**DELEGATED DECISION TO DETERMINE APPLICATIONS FOR
NON-MATERIAL AMENDMENTS**

Reference No: 2021/NM/91567/W

Site Address: 1, Rose Mount, Birkby, Huddersfield, HD2 2BU

Description: Non material amendment to previous permission
2020/90417 for erection of single storey extension

Proposed Ground Floor & Site Plan

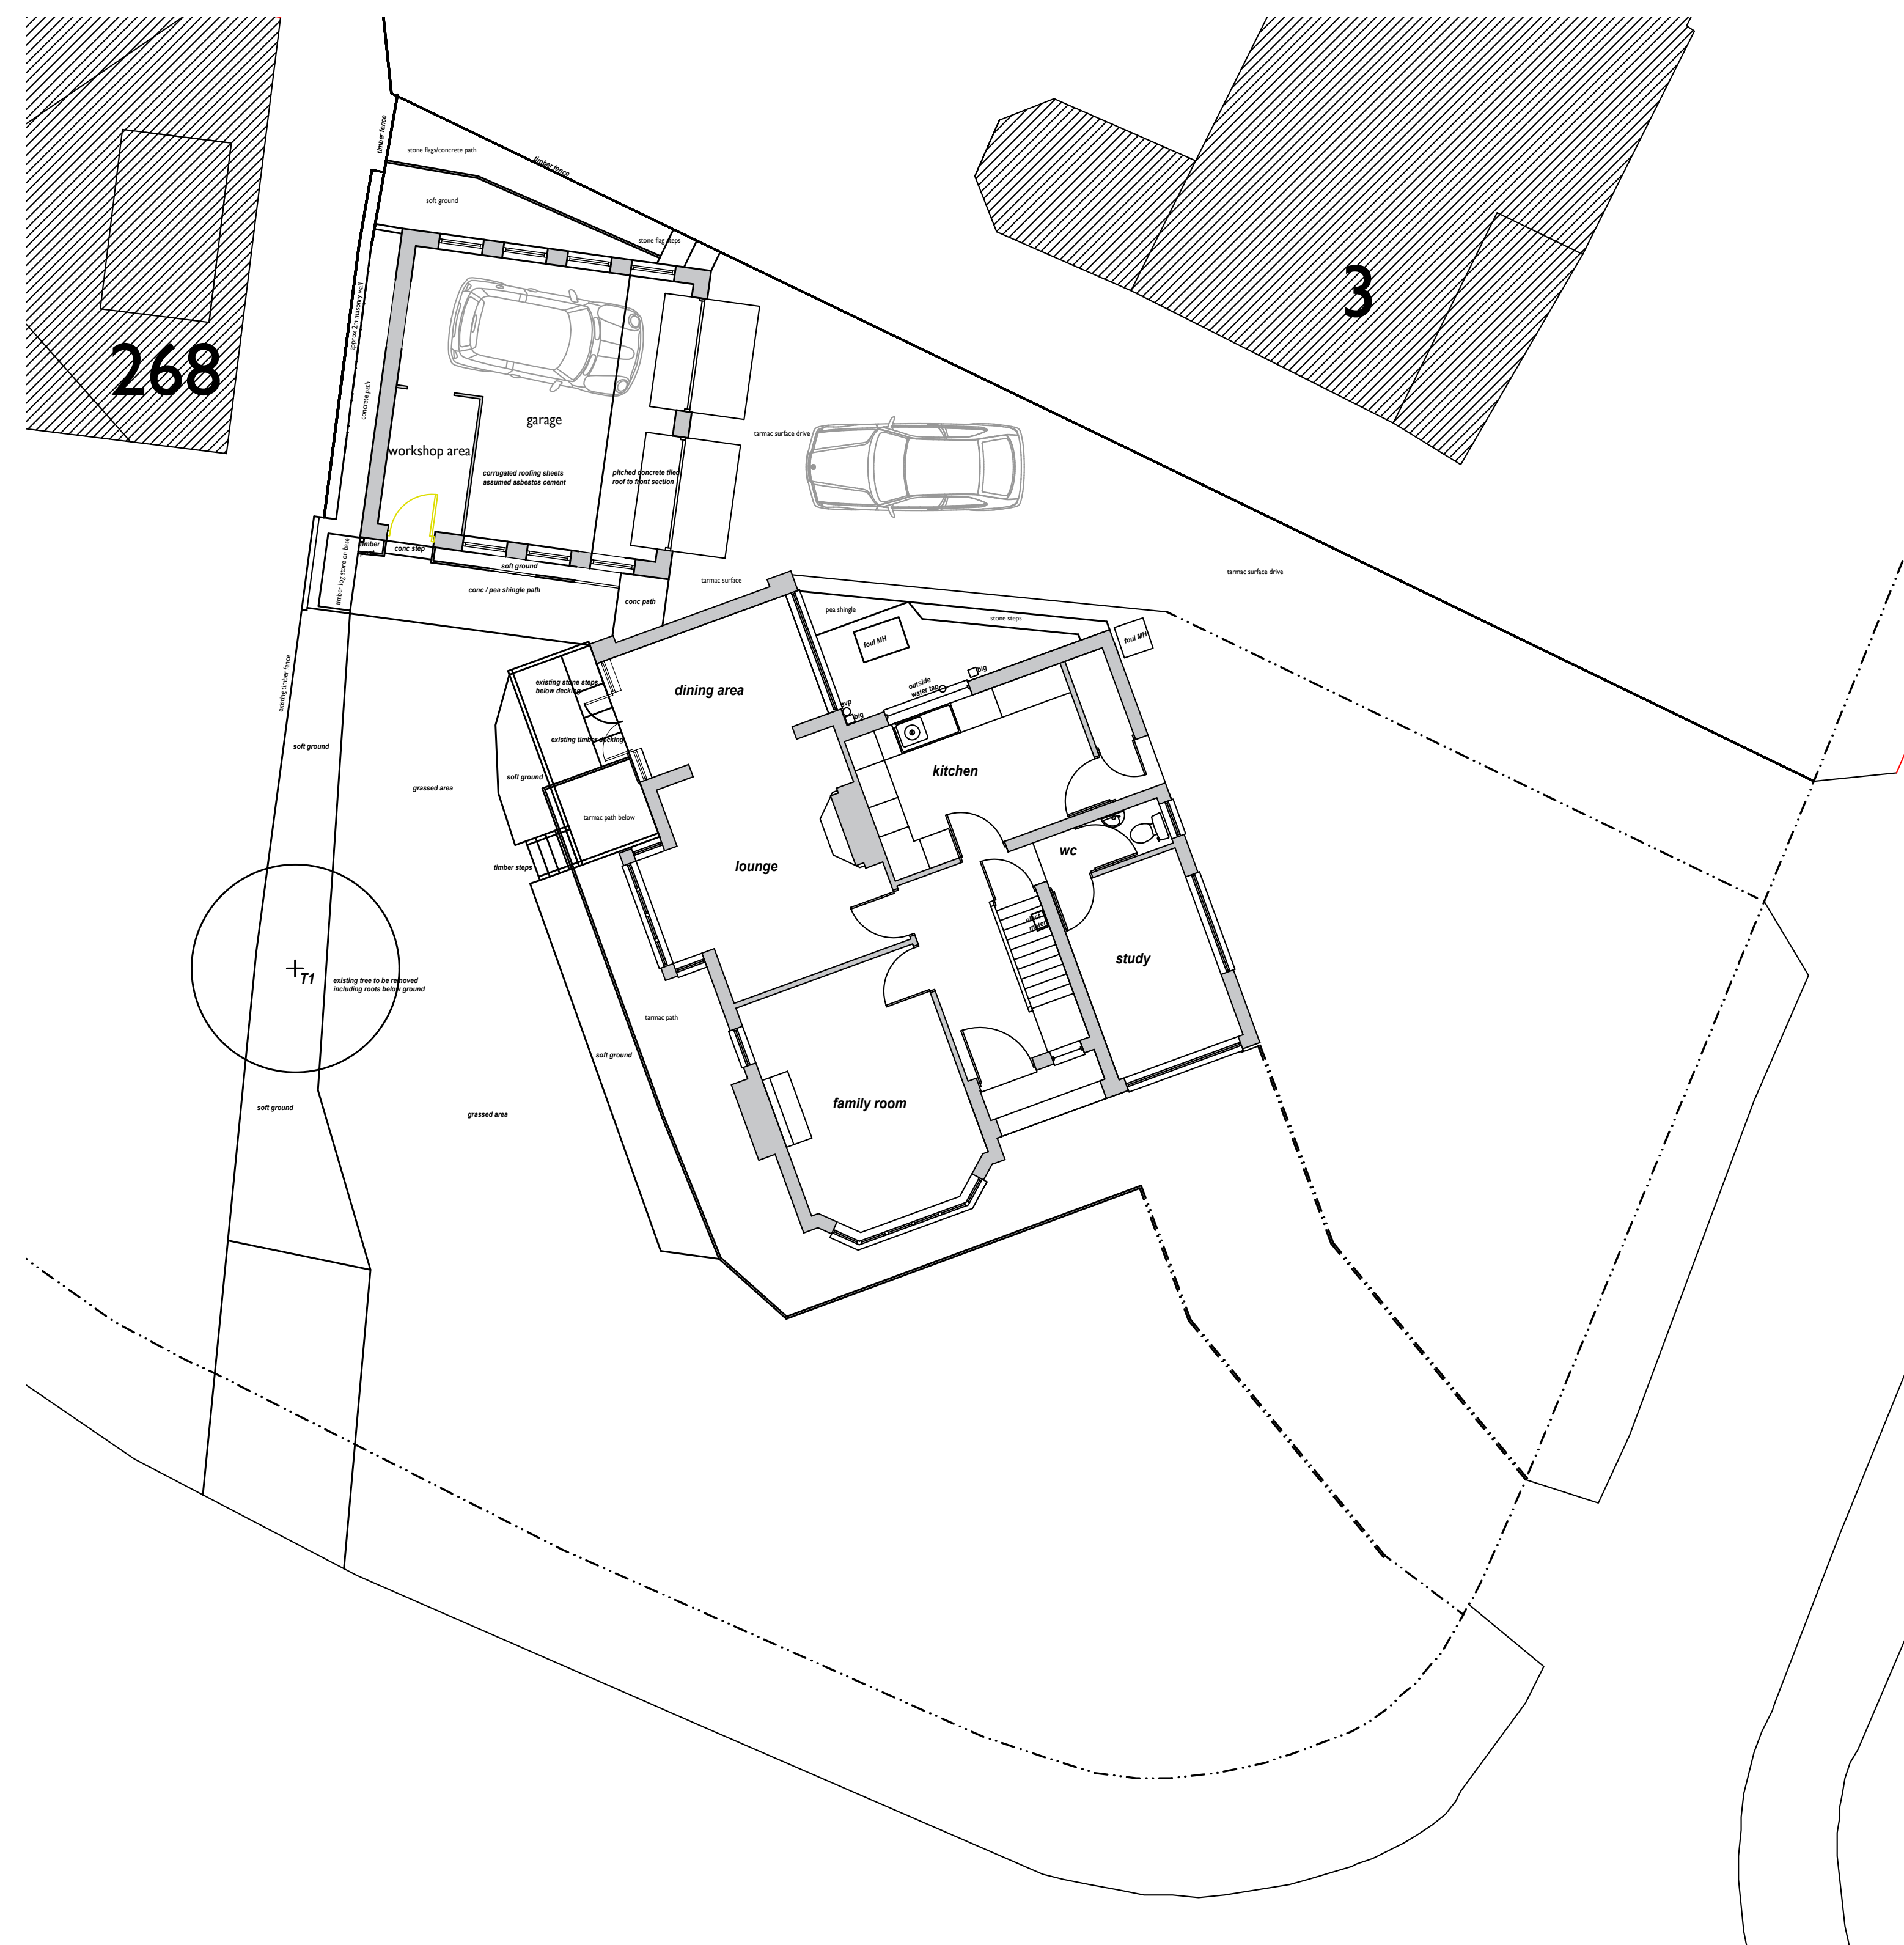
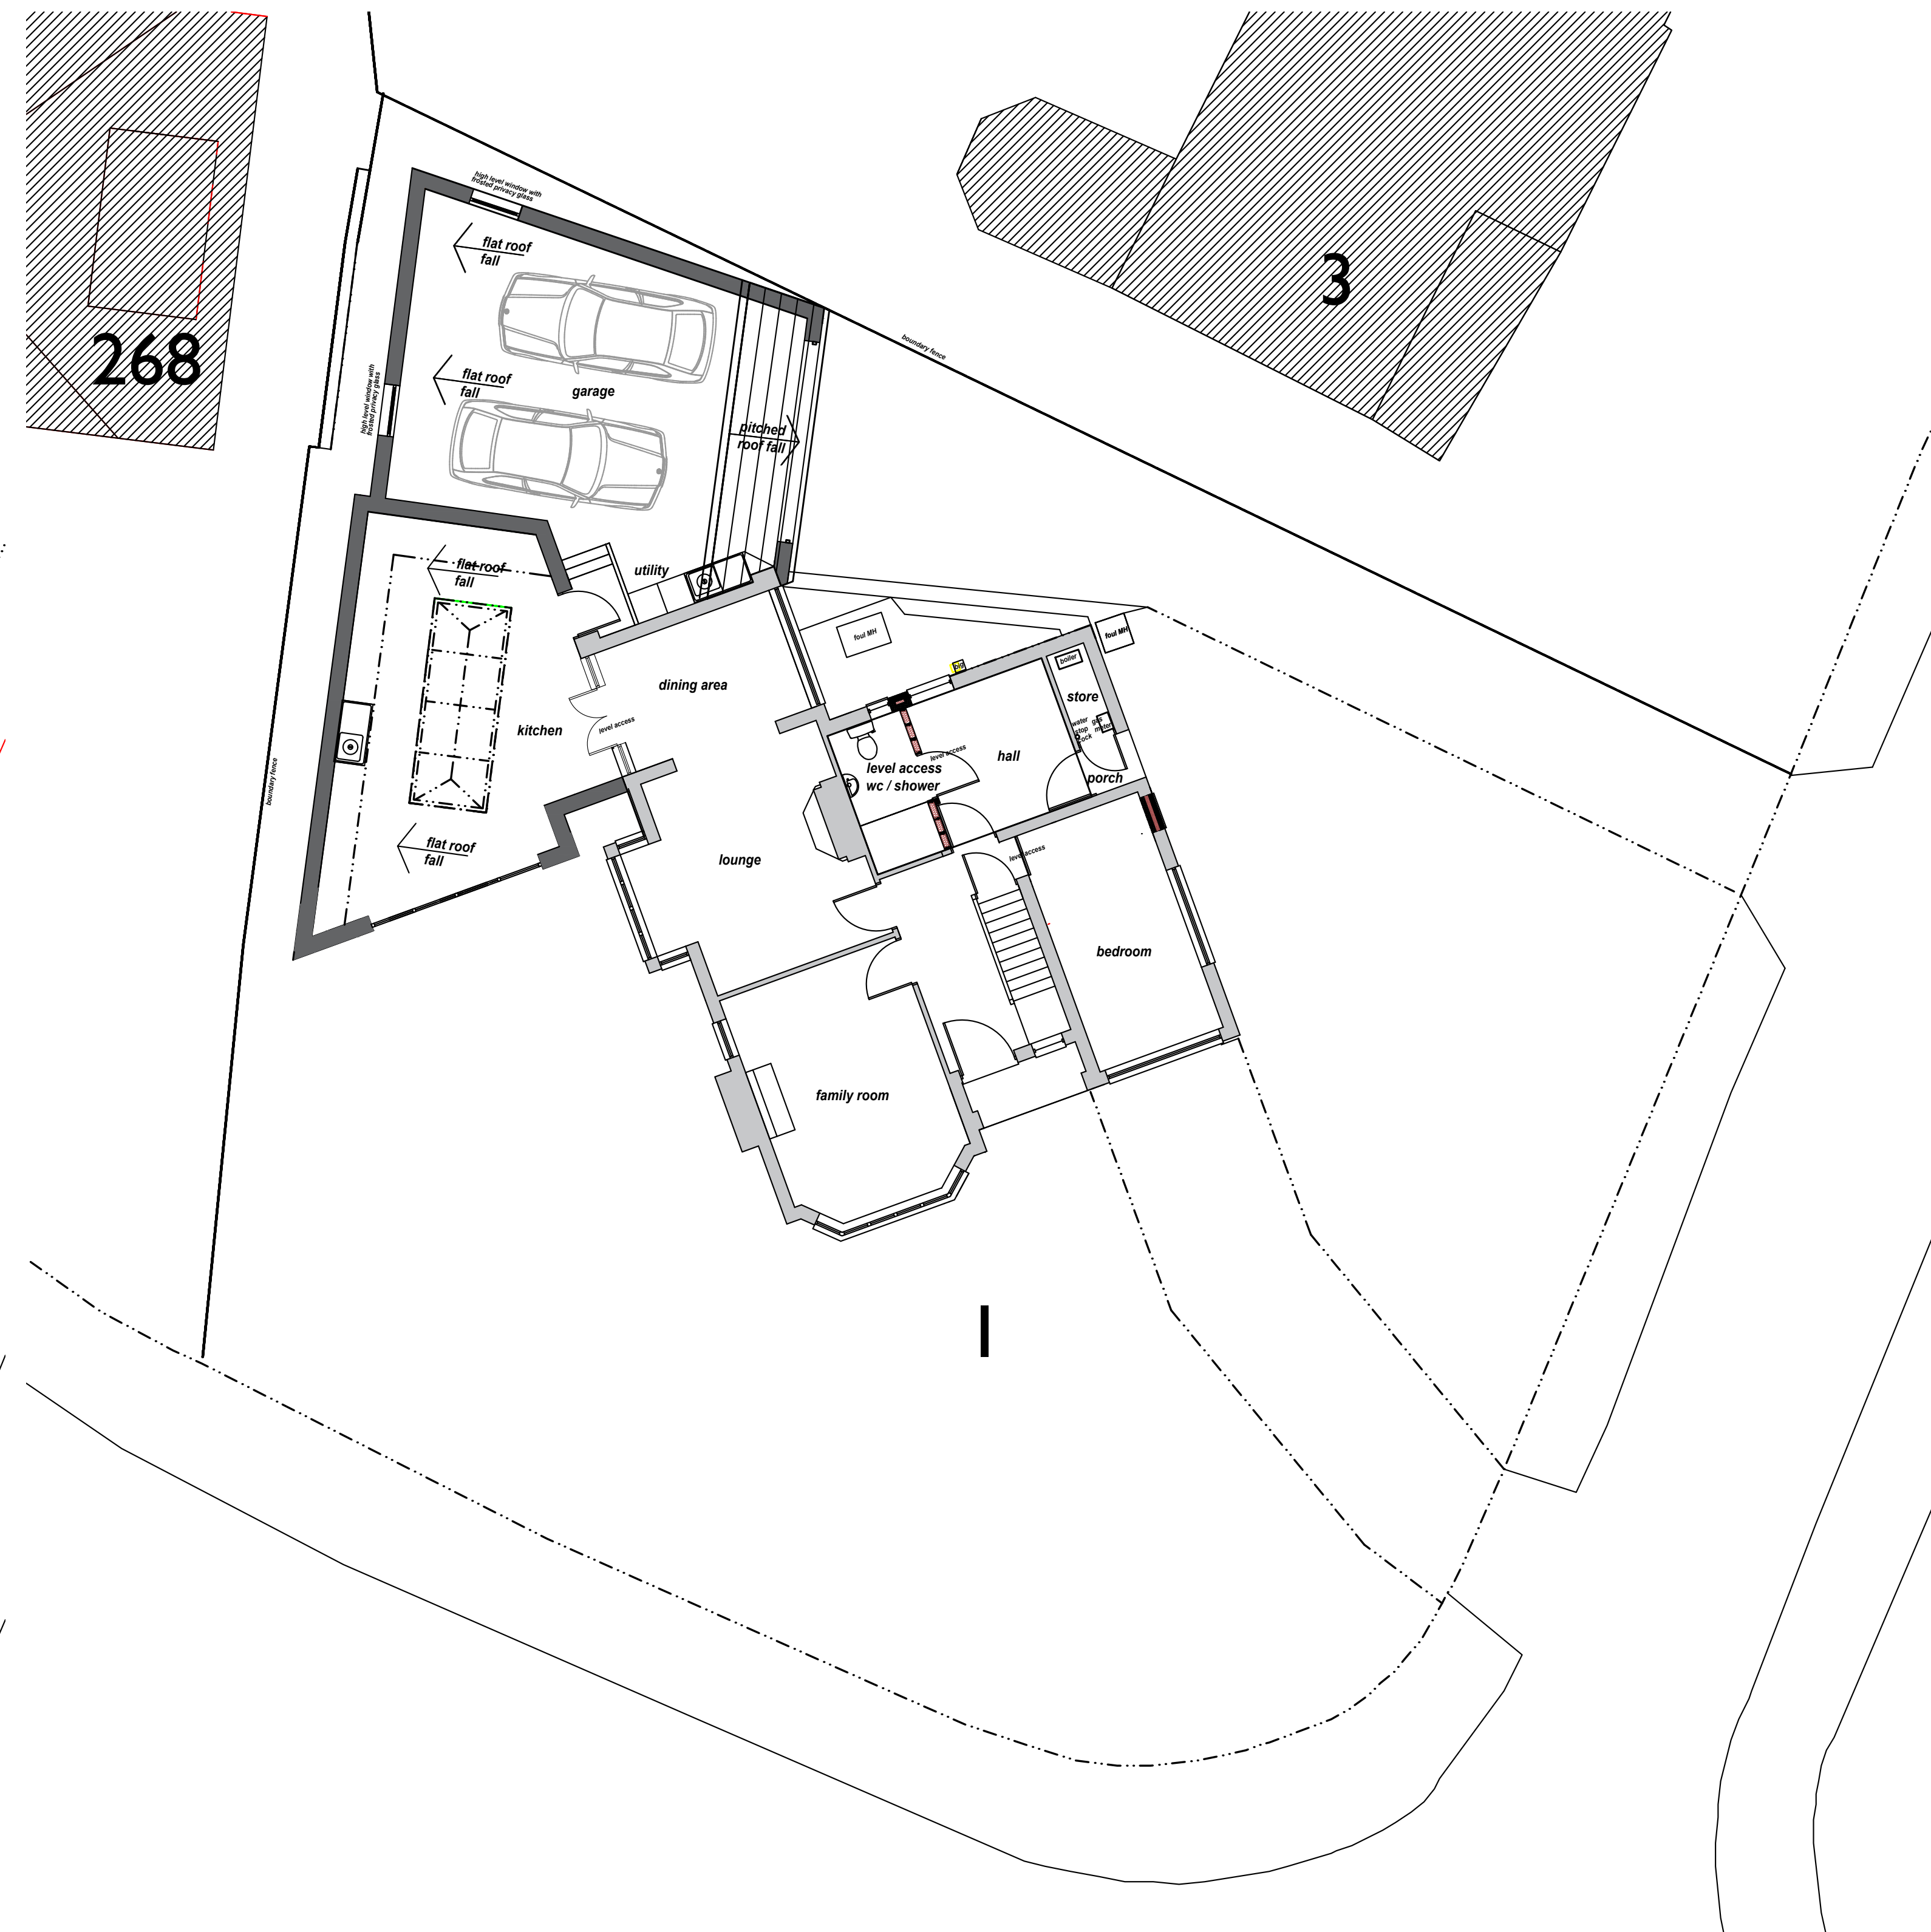
The amendment relates specifically to a longer roof lantern within the kitchen, a small set back to the rear wall of the garage and also a small pitch to the front of the garage roof.

It is noted that the plans show a side window within the garage elevation. This does not form part of this application. An application has been submitted in order to incorporate the window into the development.

The amendment sought is for a longer roof lantern within the kitchen, a small set back to the rear wall of the garage and also a small pitch to the front of the garage roof as shown on drawing numbers Revision 01 Existing and Proposed Elevations and Revision 01 Existing and proposed Floor Plans.

Note: This permission does not extend to the additional window openings within the side and rear elevations of the garage.
